# Rezone Responses to Comments

# REZONE MAP IVILO SUBDIVISION

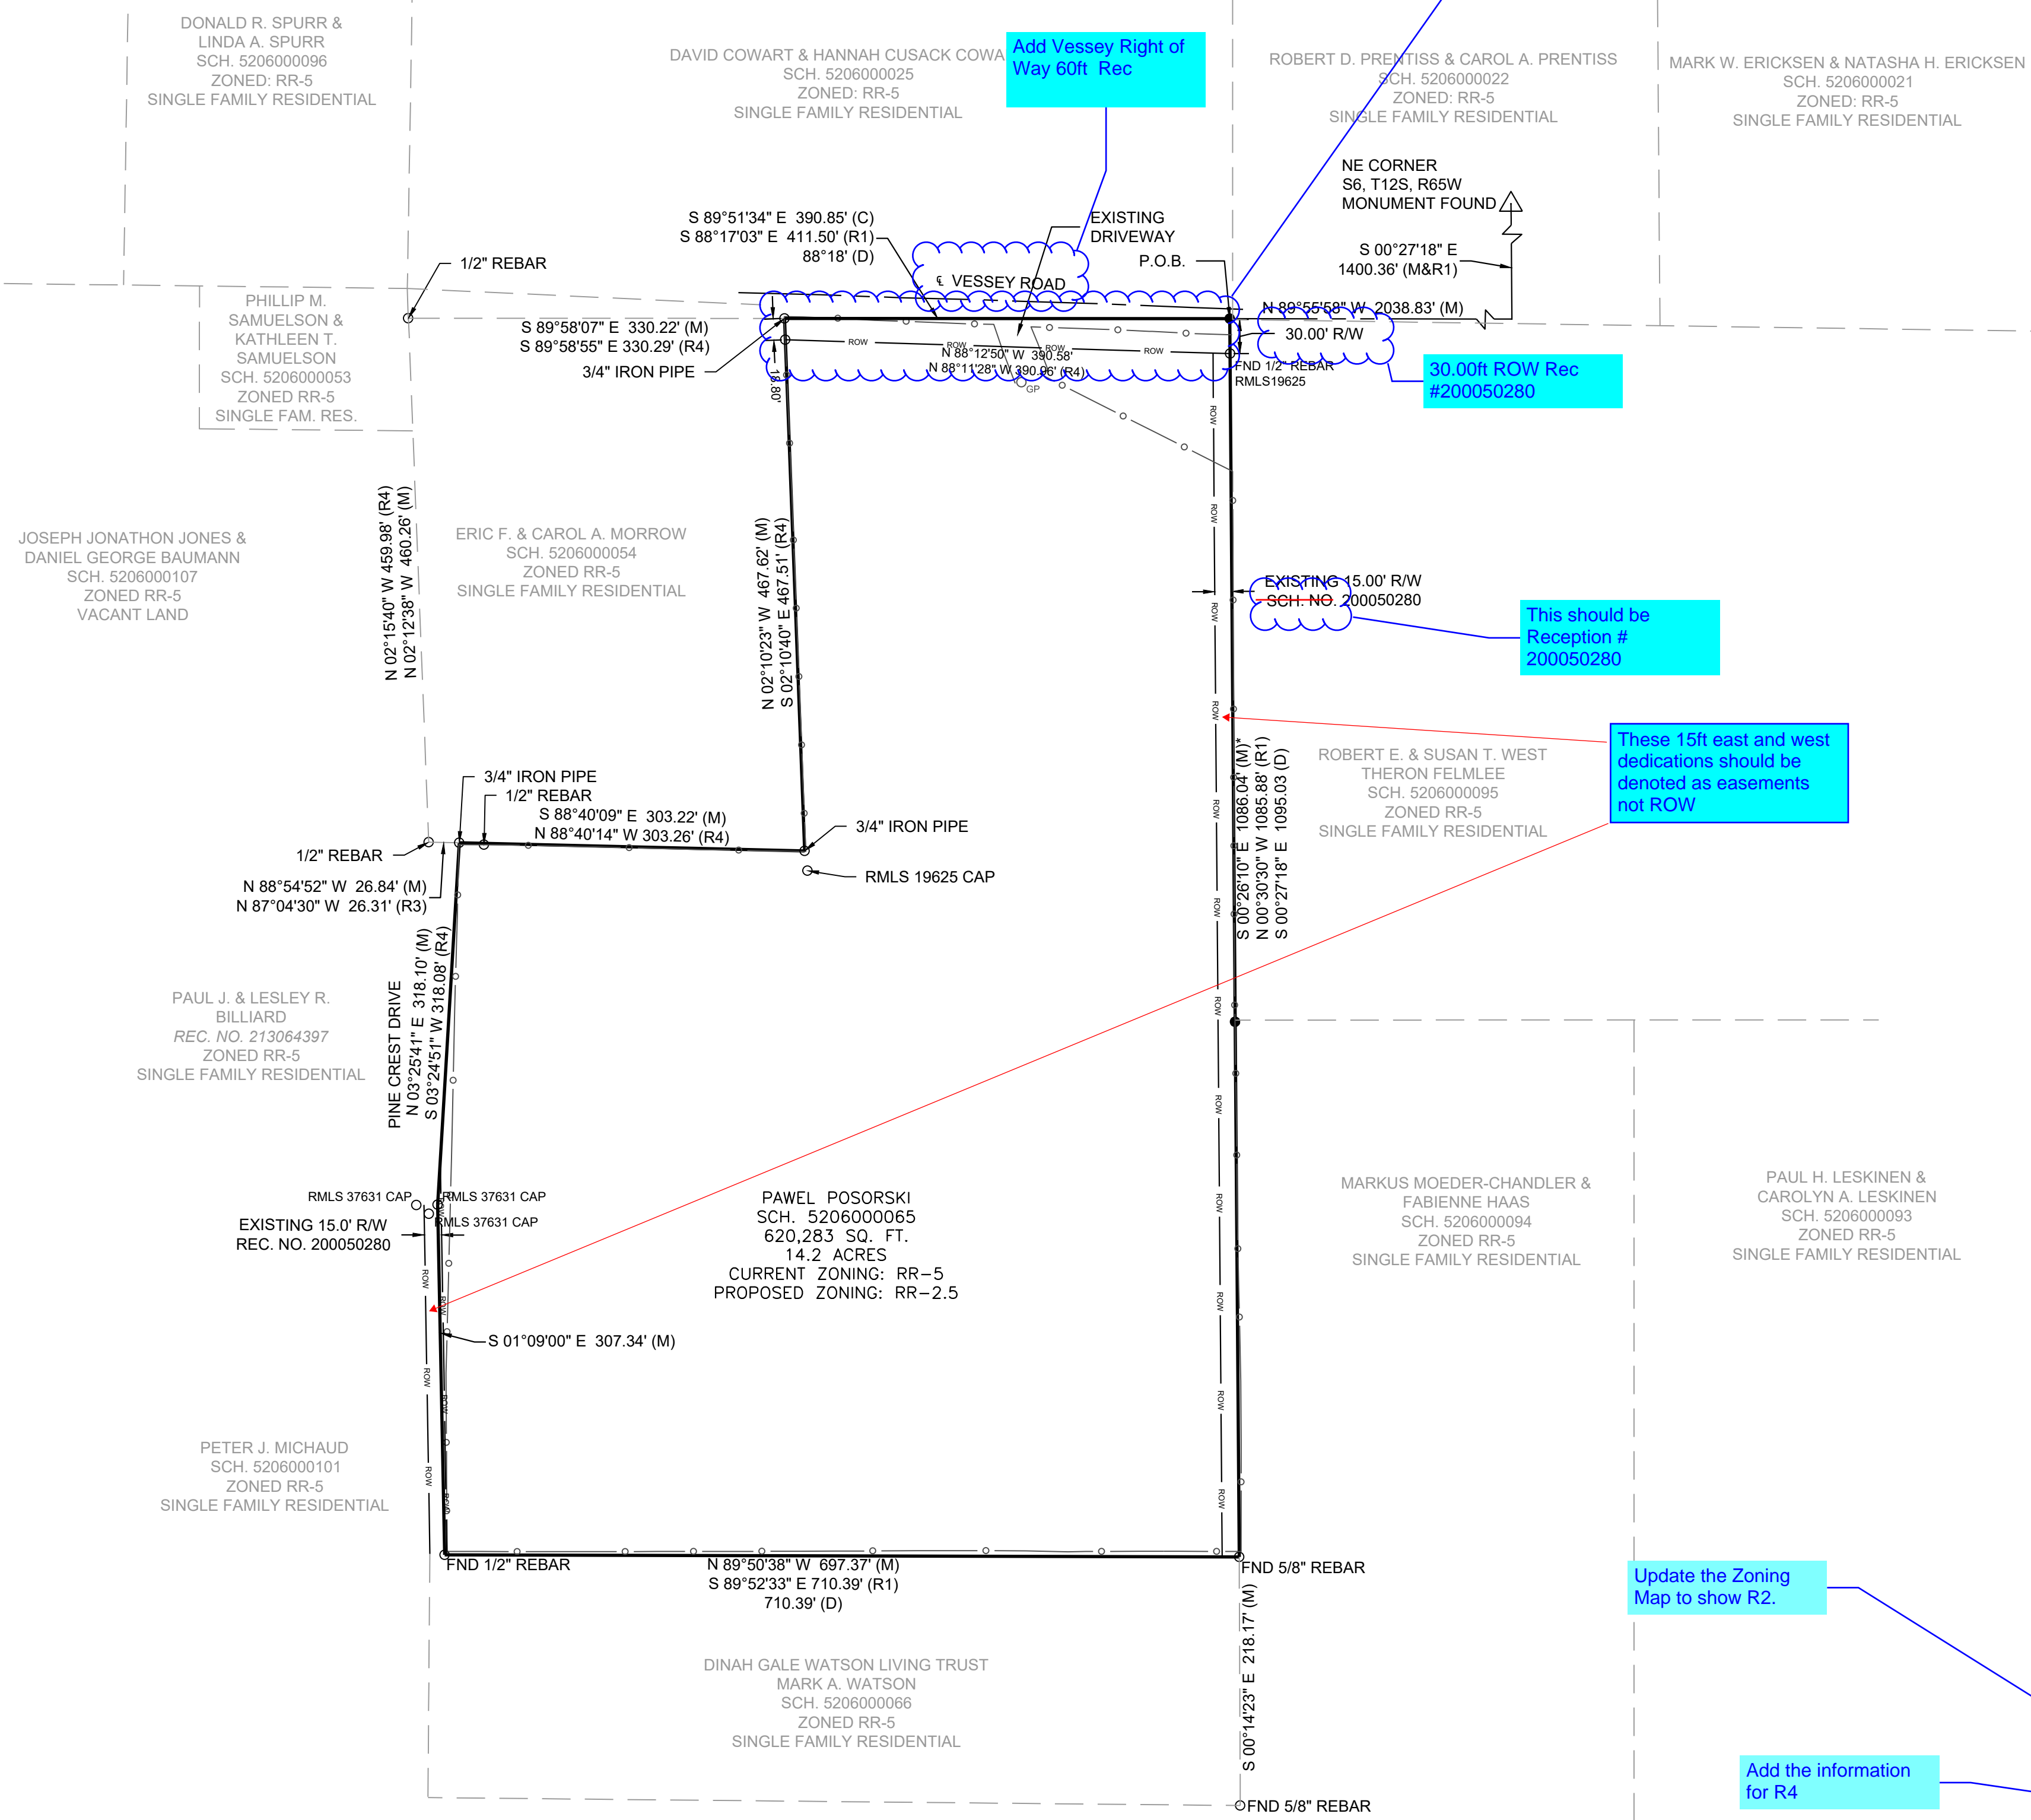
- Include more detail on each of these if you have them. **More detail added.**
- Rezone Map:
  - Add Vessey Right of Way 60 ft. Rec. **Added to rezone map.**

- Please correct line work and provide a callout detail. **Line work corrected. Call out detail not necessary.**
  - 30.00 ft ROW Rec. #200050280. **Updated.**

- This should be Reception #200050280. **Updated.**
  - These 15 ft. east and west dedications should be denoted as easements not ROW. **Updated.**
  - Update the Zoning Map to show R<sup>2</sup>. **R<sup>2</sup> callout removed from legend.**

- Add the information for R<sup>4</sup>. **Added.**
  - 410' according to the assessor's drawing – confirm it is correct. **Confirmed dimension shown is correct.**

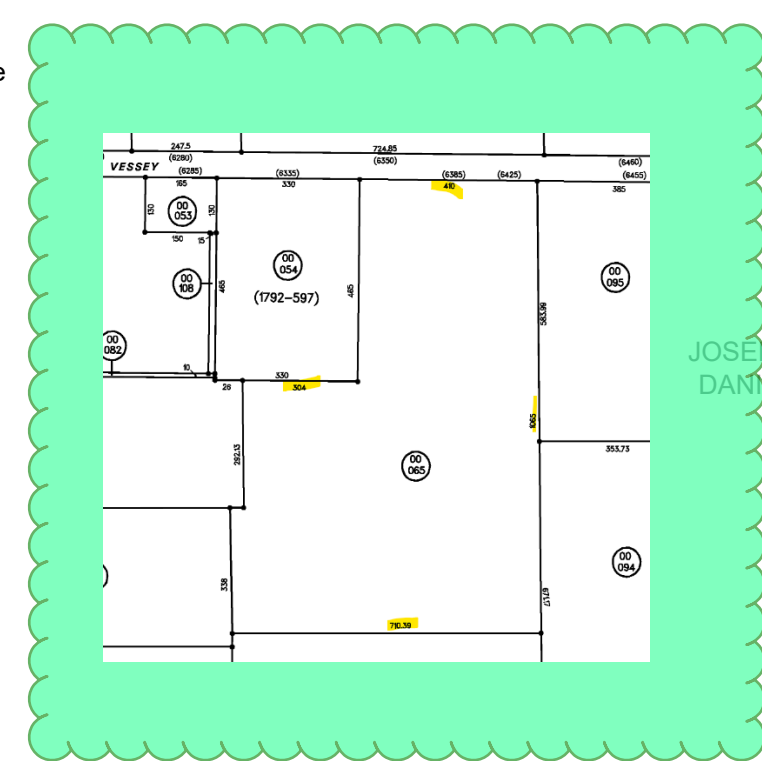
- Confirm that this point is correct. The assessor's site (above) shows a jog in this location. **Updated to match Assessor's site. However, does not match plat. Due to the metes and bounds descriptions of this property and the adjacent properties, and the starting points of those descriptions, there is overlap in the parcels and their descriptions. The final plat represents the new property boundary to clean up the overlaps that exist. Quitclaim deeds to clean up these areas of overlap have also been included with this application.**
